City of Albuquerque Stormwater Construction Site Inspection Report

ESC File No.	R16E101	Project Name:	Encanto Apartments
NPDES Id. No.	NMR1004QH	Location:	5501 University Blvd SE
5/16/2024	Owner	Contractor	
Operator	Encanto QOZB LLC	Pavilion Construction	
Contact name & title	Clayton Damron	Paul Lamb	
	cdamron@cruchancapital.com	plamb@pavilionconstruction.com	
Contact Phone #	972-665-8792	505-346-0085	
COA Inspector	Chance English	Start/End Time:	10:30am
Construction Phase:	Verticals		
Type of Inspection:	<input checked="" type="checkbox"/> Regular	<input type="checkbox"/> Storm Event	<input type="checkbox"/> Past Storm Event >0.25" <input type="checkbox"/> 311/Complaint <input type="checkbox"/> Follow Up
Weather at time of inspection?	Rain	Temperature: ~	60
Estimated date of last storm 0.25" or greater	4/1/2024

EROSION AND
SEDIMENT CONTROL PLAN
ENCANTO APARTMENTS
MESA DEL SOL

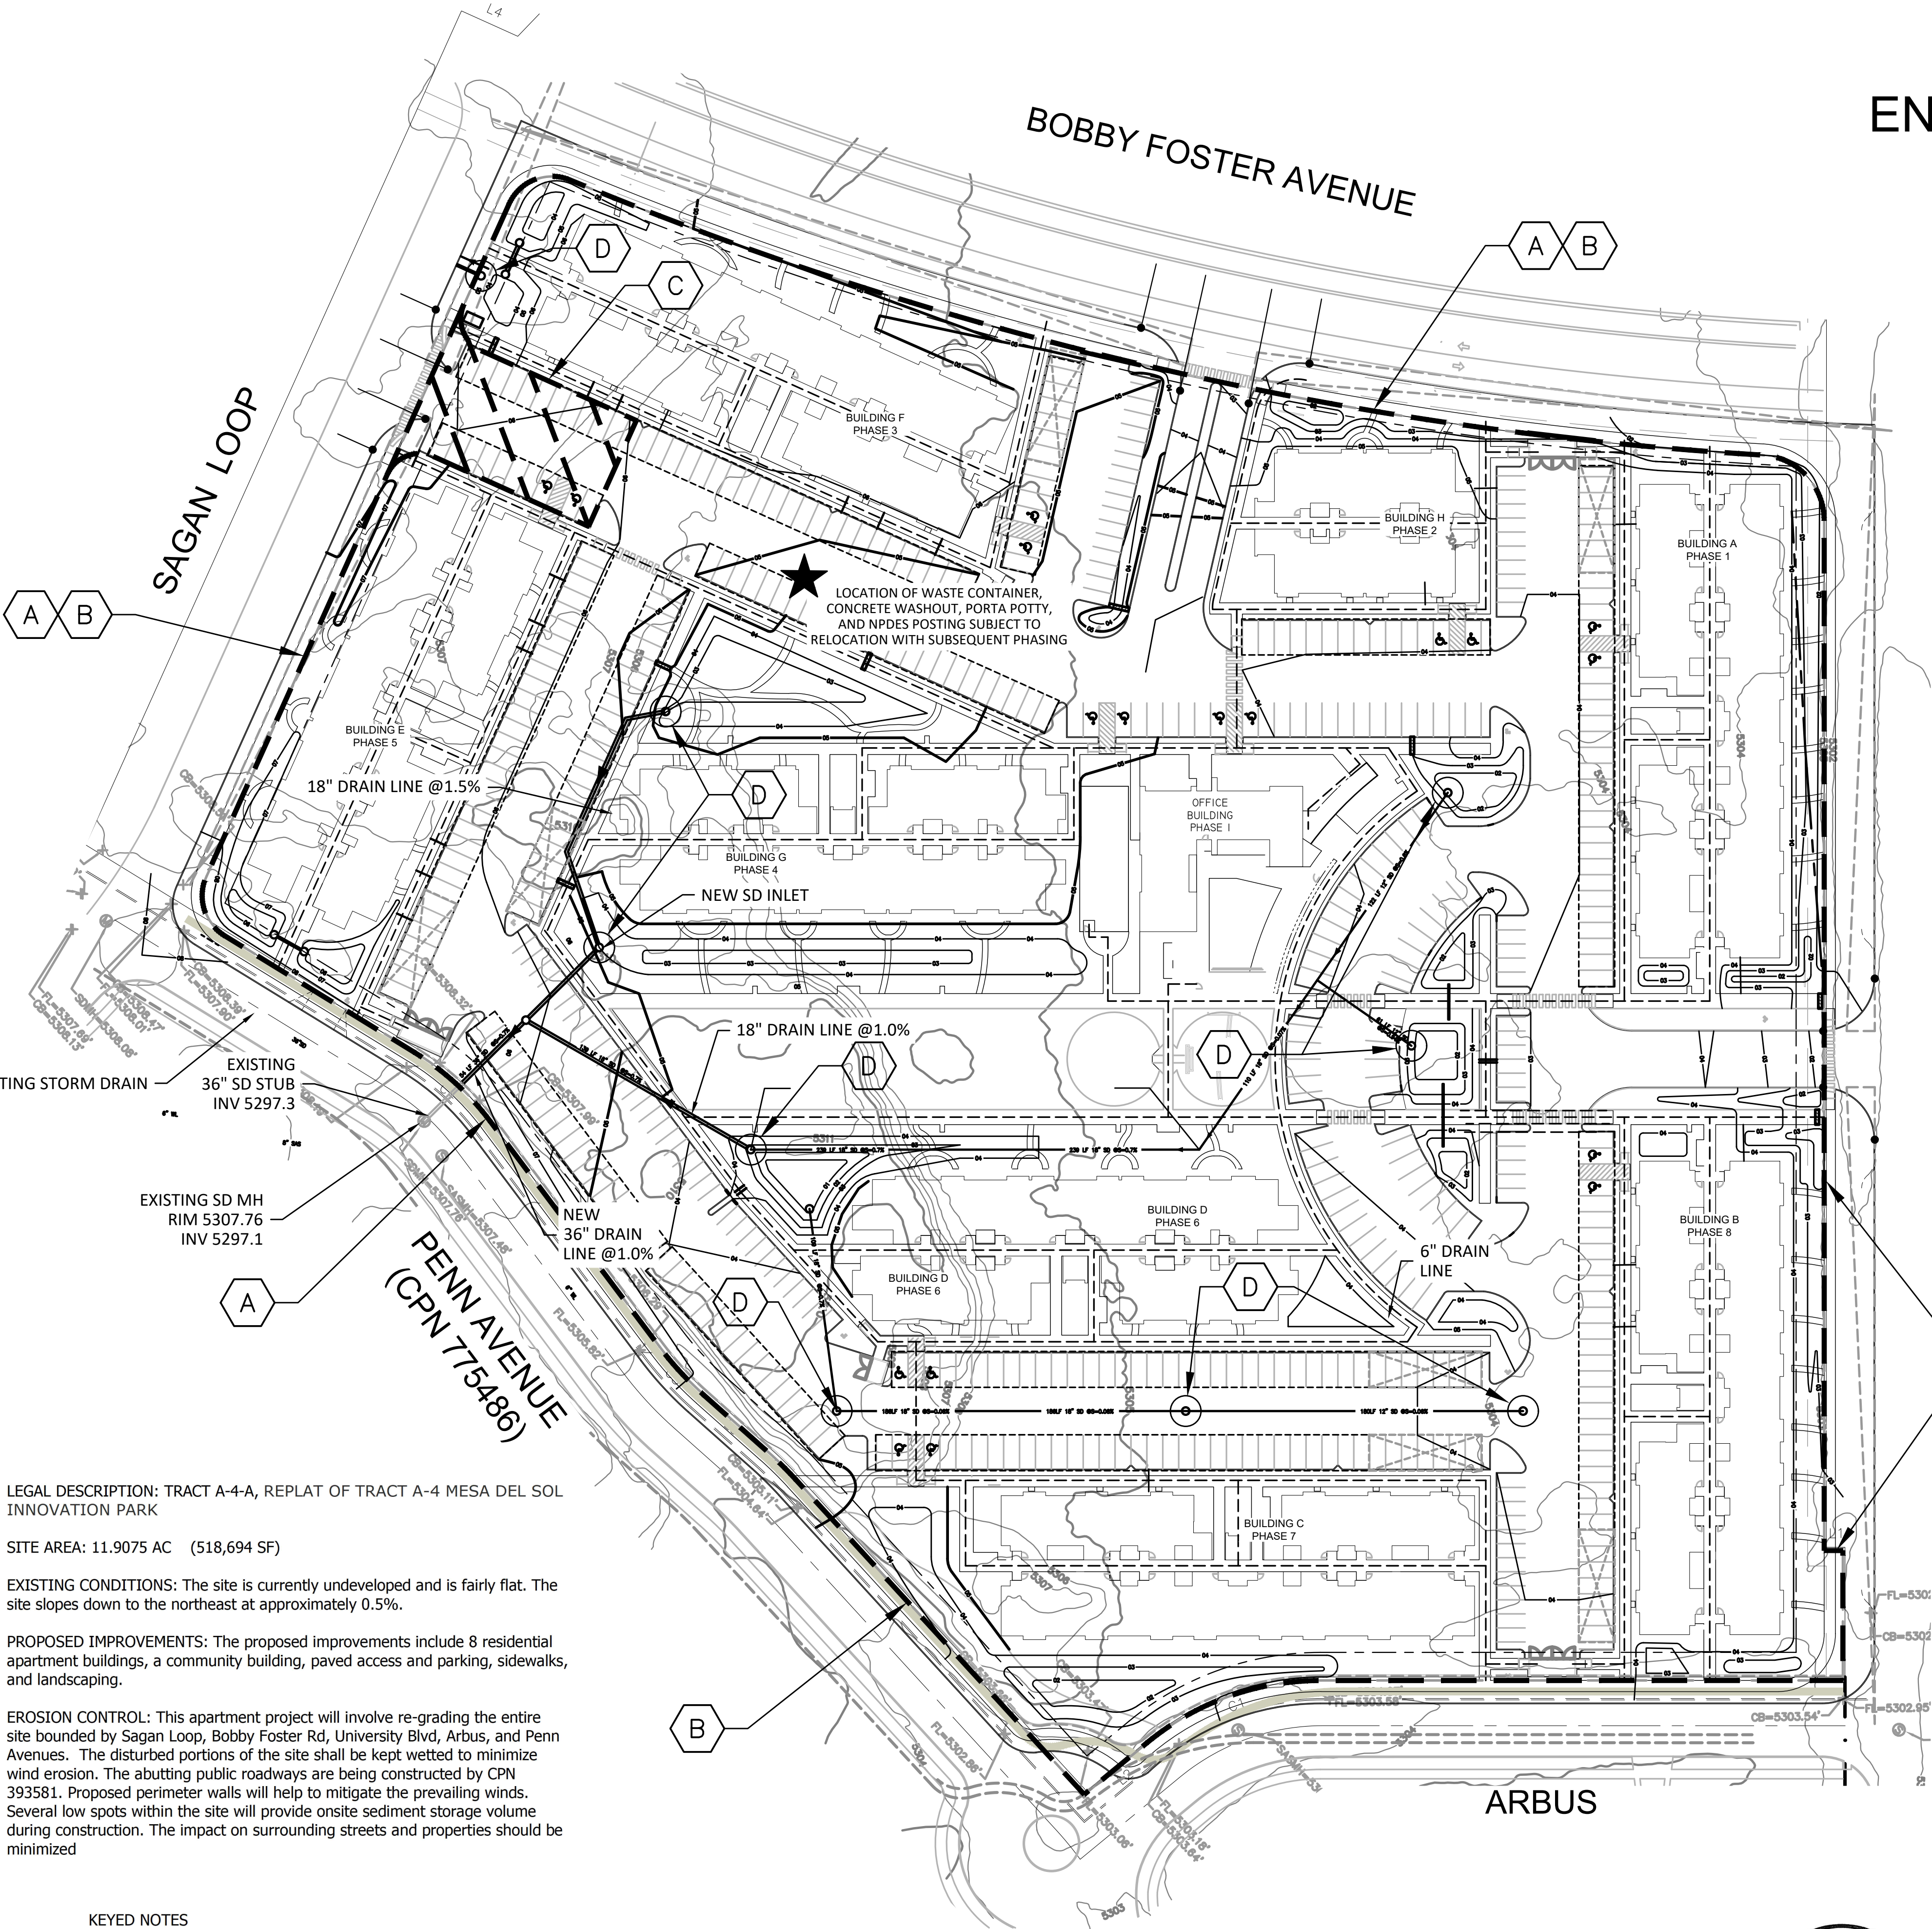
3	There is a pile of dirt that was deposited on Strand Loop Rd in violation of CGP Part 2.2.4. Required mitigation: Where sediment has been tracked-out from your site onto paved roads, sidewalks, or other paved areas outside your site, remove the sediment by the end of the same business day in which the track-out occurs per CGP Part 2.2.4.d.
